## Response to Submissions

UNSW D14 Academic Building, Kensington  
Campus  
State Significant Development (SSD 9606)

Submitted to Department of Planning and  
Environment

17 April 2019 | 218568

GROUND - LANDSCAPE PLAN (LANDSDCAPE PLAN FROM LANDSCAPE REPORT)

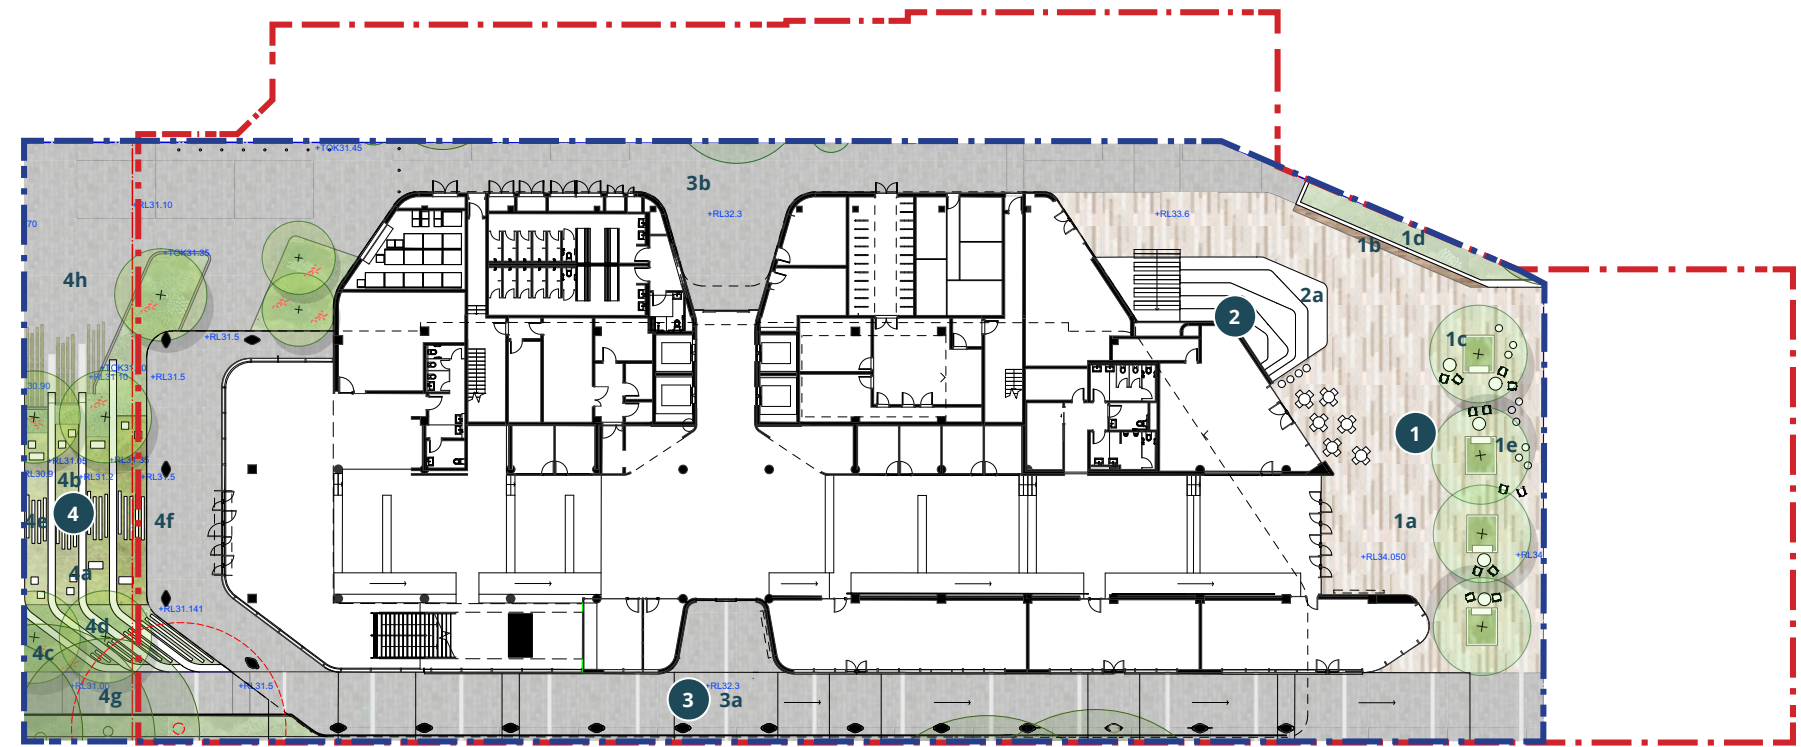
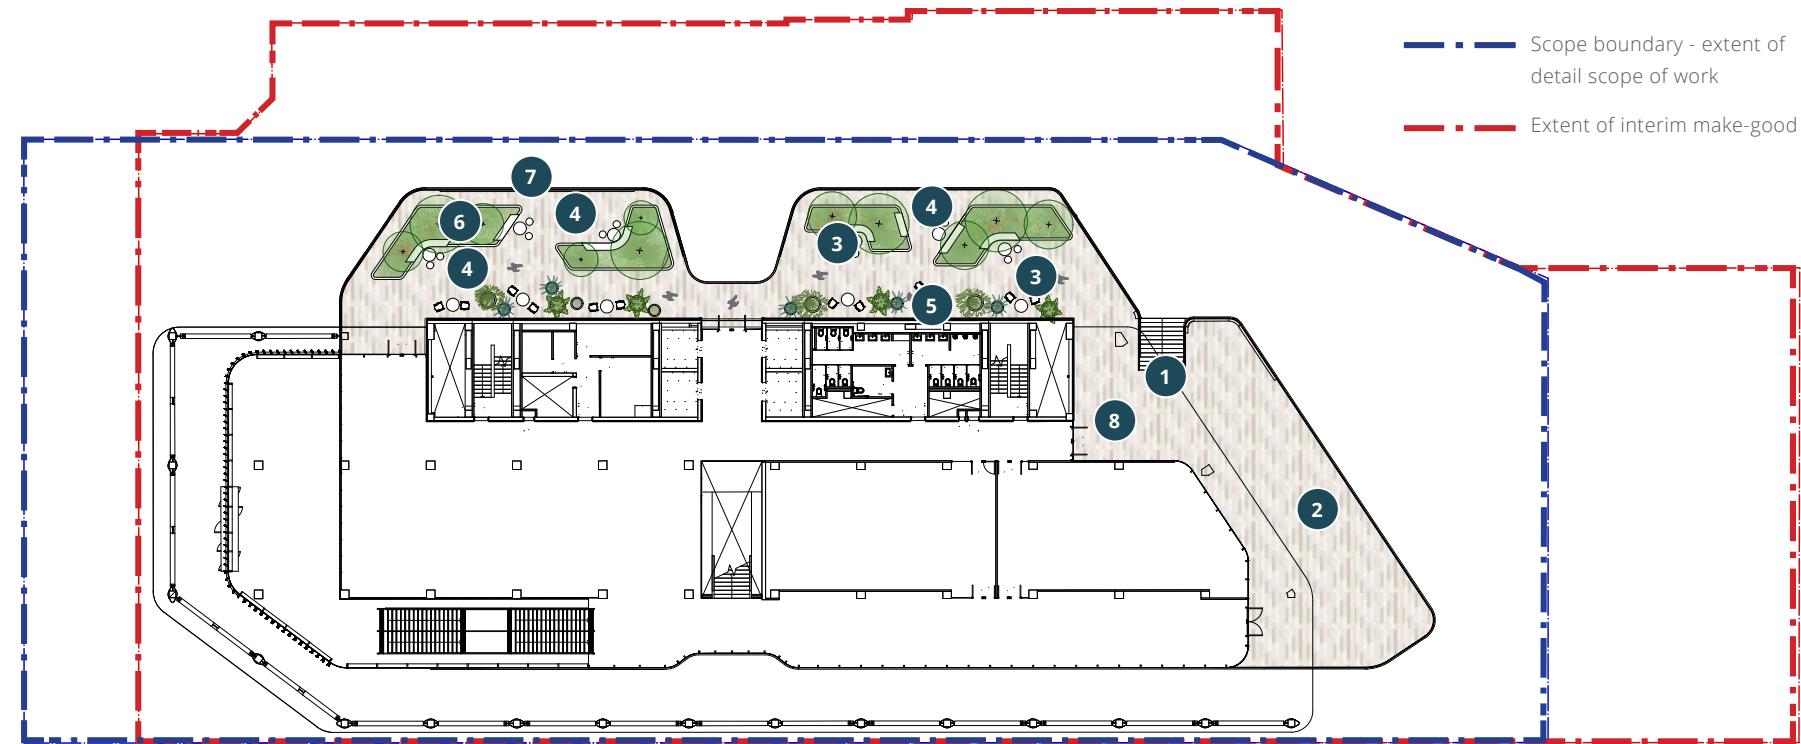
- The OEH recommends that the development incorporate green walls, green roof and or a cool roof in the design of the building. Specific green cover opportunities are identified to increase overall area of landscaping at the Level 1 terrace, the Alumni Terrace and the Fig Tree Courtyard Space and White Bleachers.
- Additionally, increasing the green space would be consistent with Item 5 of the SEARS requirements.

The extent of landscape area on the Level 1 terrace has also been increased and consists of an open lawn area, some mounded landscaping and tree plantings to the north west edge and additional plantings in large planters with integrated seating opportunities. Soil depth within some of the planters will be deep enough to accommodate small evergreen trees and have been oriented with an objective to provide an enhanced transition and separation to the university's residential accommodation to the north of the site.
